## **LATE SCOPING CONSULTATION RESPONSES**

Seabank Power Station, Severnside, Bristol

**Our ref:** WX/2013/123155/01-L01  
**Your ref:** 130213\_EN010058\_1654674  
**Date:** 27 March 2013

**EIA SCOPING REPORT 12 FEB '13 - PROPOSED COMBINED CYCLE GAS  
TURBINE POWER STATION AT SEABANK POWER STATION, SEVERNSIDE,  
BRISTOL**

Figure 10: Indicative Access Points and Route of the Red Rhine and New Spine Road

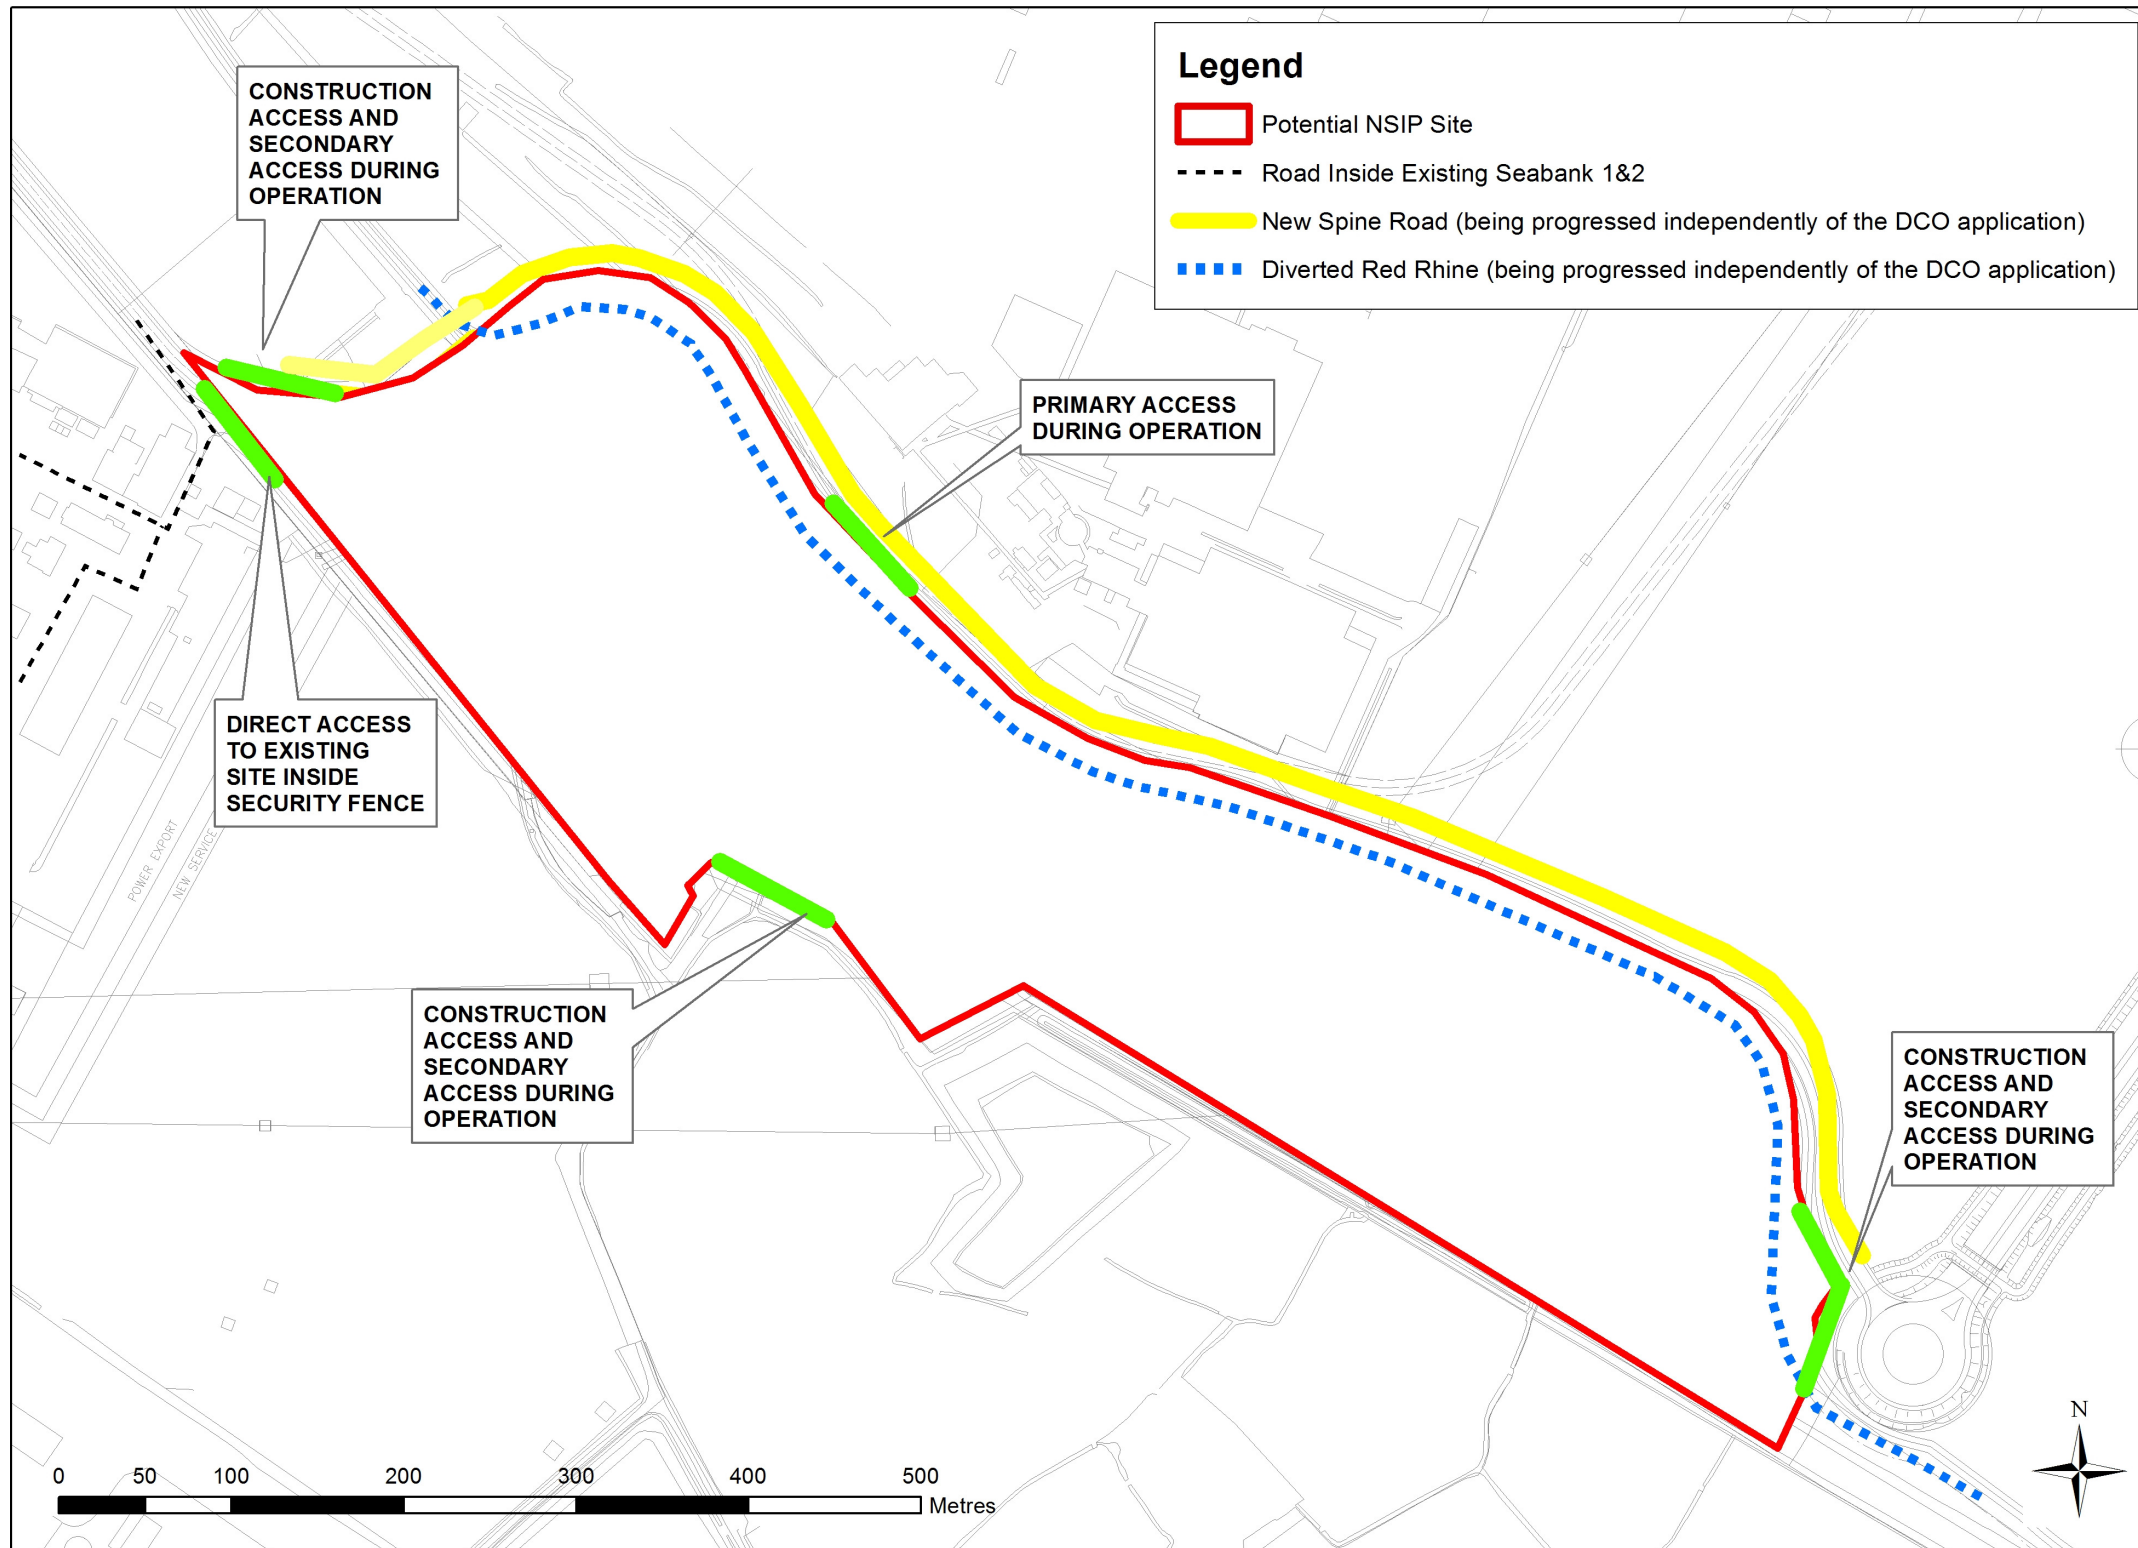
We note the proposal to divert the existing Red Rhine and acknowledge that the Lower Severn Internal Drainage Board is the appropriate body to agree the design and decide whether the proposals are satisfactory.

The aspect of the proposal we would have most concerns about is the diversion of the Red Rhine. As stated, the rhine acts as a corridor for migrating eels and as such full consideration should be given to the Eels Regulations (2009) to ensure safe passage when proposing mitigation measures. Although this responsibility will fall to the Lower Severn Internal Drainage Board, it is worth reiterating.
